Recommendation Report for Planning Permission for Works or Extension to a Dwelling

REF NO: BE/114/25/HH

LOCATION: 39 Sherwood Road
Bersted
PO21 9DR

PROPOSAL: Removal of existing conservatory / porch and erection of single storey front extension.

Sheet 1 of 3

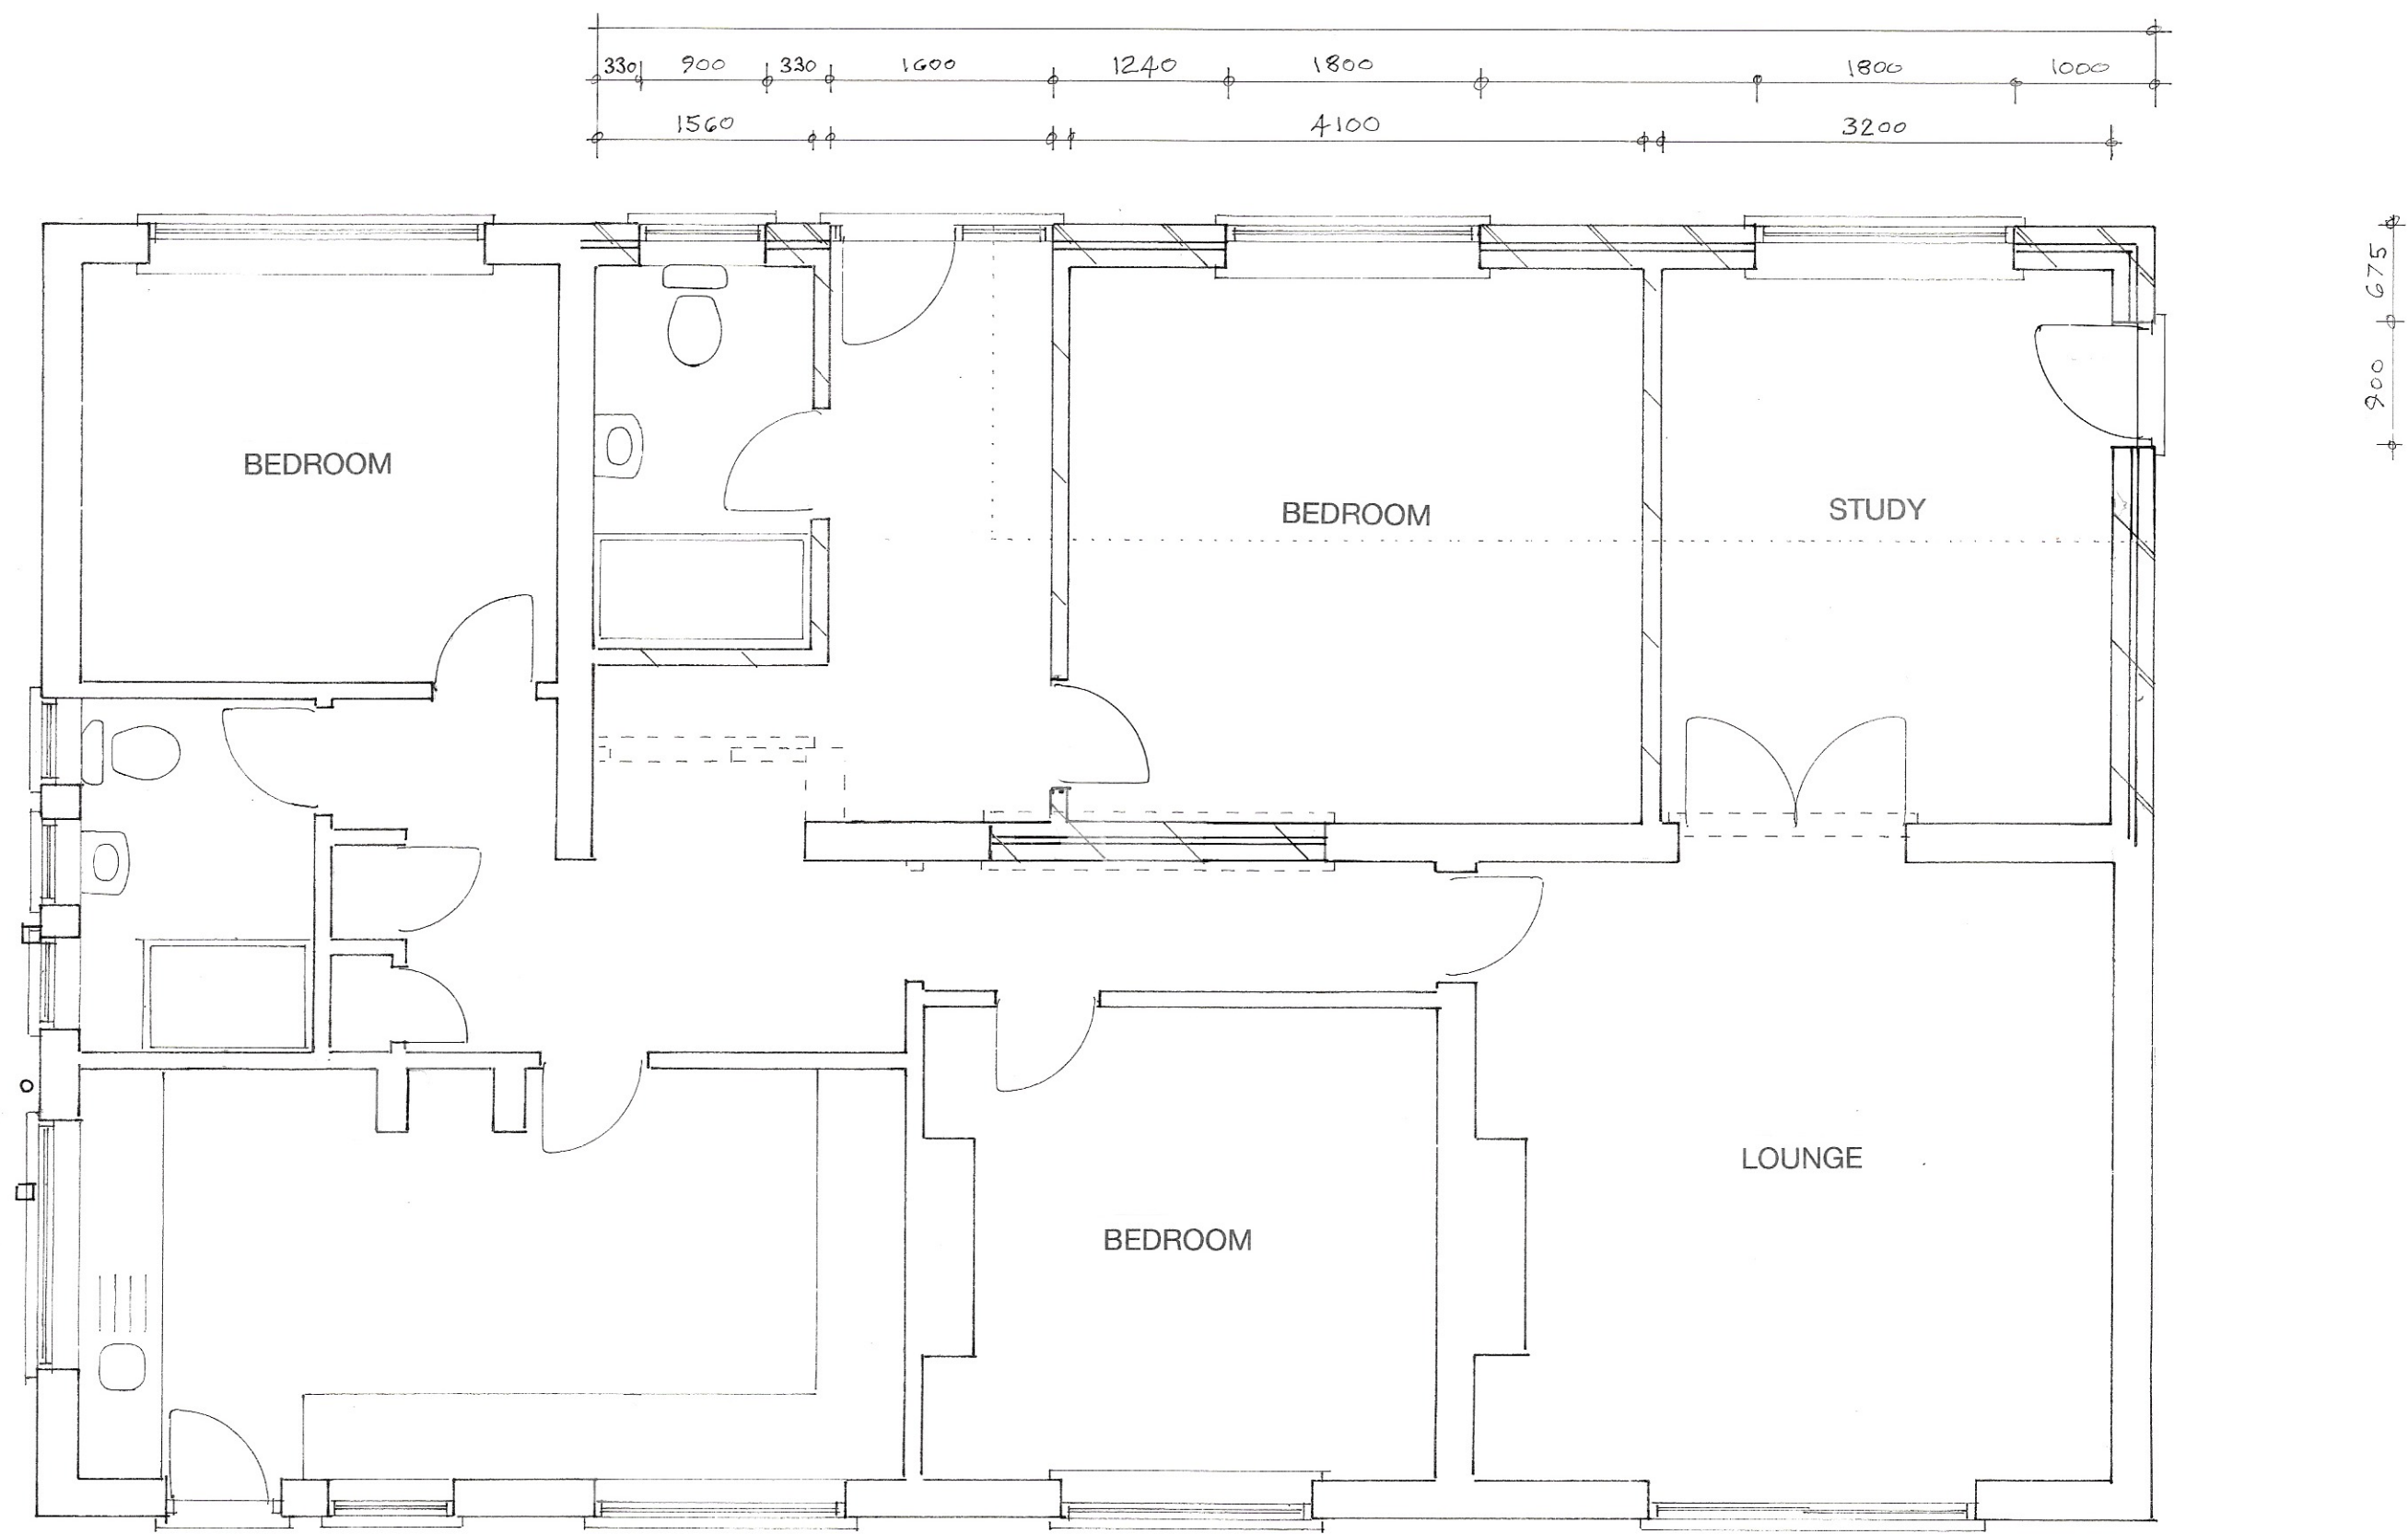
The extension would measure a maximum of 4.3m in depth, creating an infill addition that spans the full width of the dwelling, resulting in an overall width of approximately 15m. It would have a flat roof form with a height of 2.9m. External brickwork would match the existing materials, ensuring visual integration with the host dwelling, in accordance with policy D DM4 of the Arun Local Plan.

Sheet 2 of 3

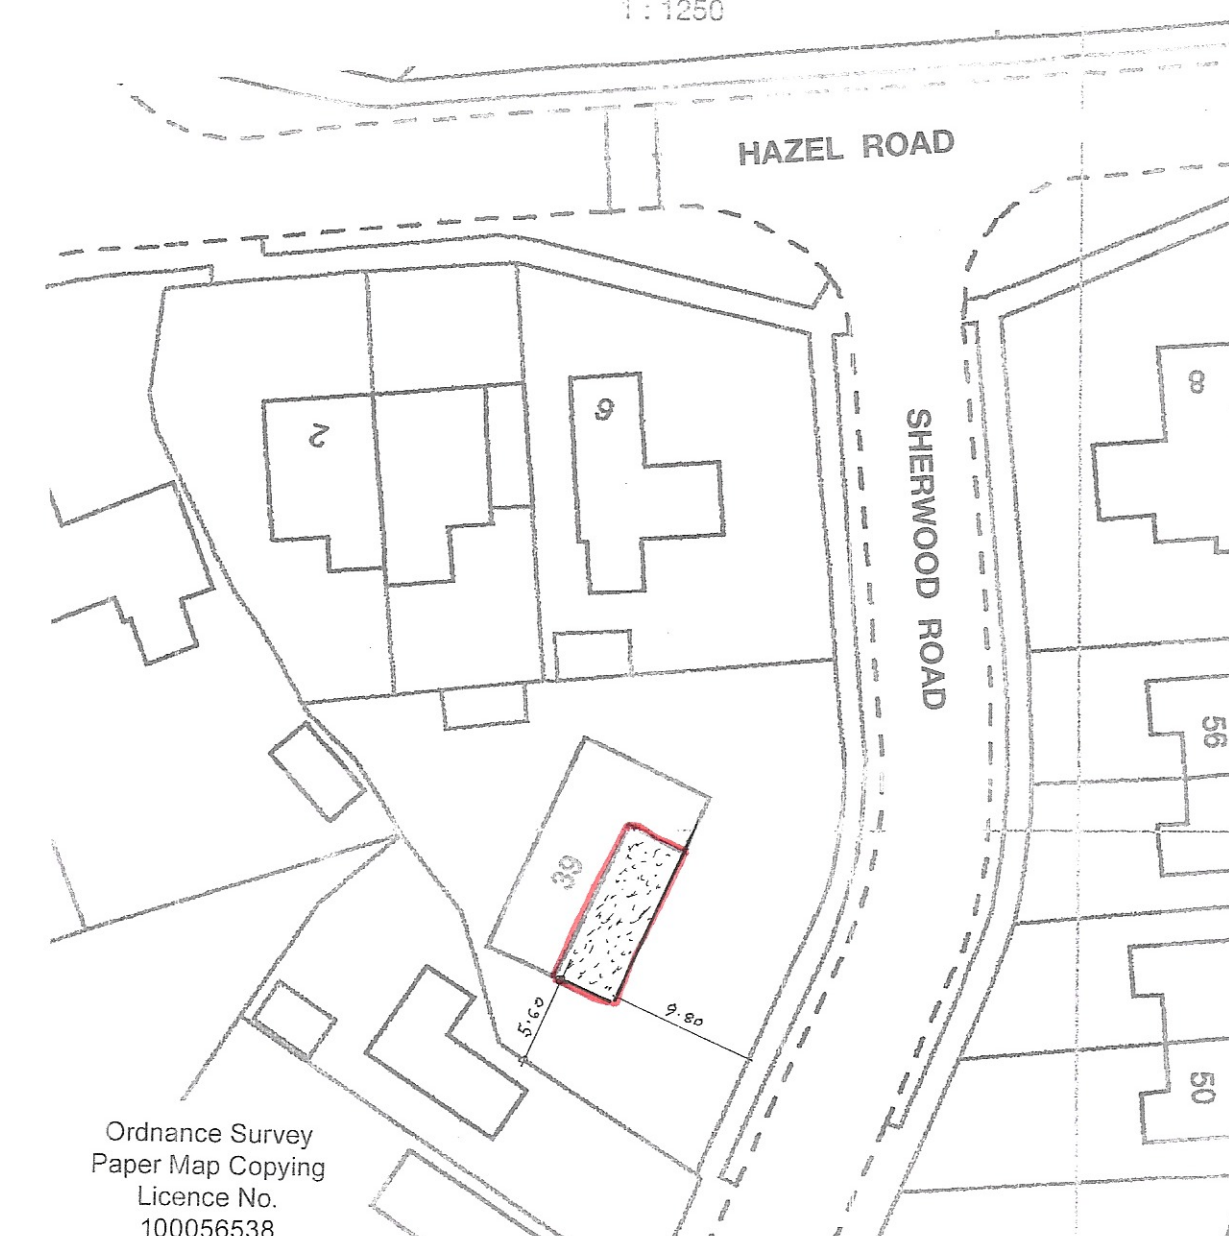
Fenestration to the front (south eastern) elevation would include two uPVC windows, a new uPVC entrance door flanked by a small window, and a new door to the side (south western) elevation. The proposed windows would be consistent with the existing dwelling and would be acceptable in terms of design and appearance.

The extension would be visible within the street scene, which is staggered and features other flat roof, single storey front projections. While the extension would have a larger footprint than the existing conservatory, it would be in keeping with the character of the surrounding area.

The proposed depth of the front extension would be in conflict with the guidance set out in the Arun Design Guide (ADG), which states that front extensions should not be deeper than 1.5m. However, the overall scale and massing would be proportionate to the host dwelling, and sufficient front garden space with a depth of approximately 9.8m would remain. Therefore, the proposed extension is acceptable in this instance.

Although the proposed extension would not be set back from the principal elevation of the host dwelling, contrary to Section M of the ADG, this deviation would not result in harm to the character or visual appearance of the property. The existing conservatory is already partially aligned with the front elevation, and the proposed change would represent only a slight alteration. As such, the proposal would not result in harm to the character of the host dwelling in this instance.

The proposed front extension would be set approximately 5.6m from the south western side boundary and would not be visible from the northern side boundary due to the existing front projection. The proposal would therefore maintain adequate separation distances to neighbouring properties and would not result in overbearing or overshadowing impacts.
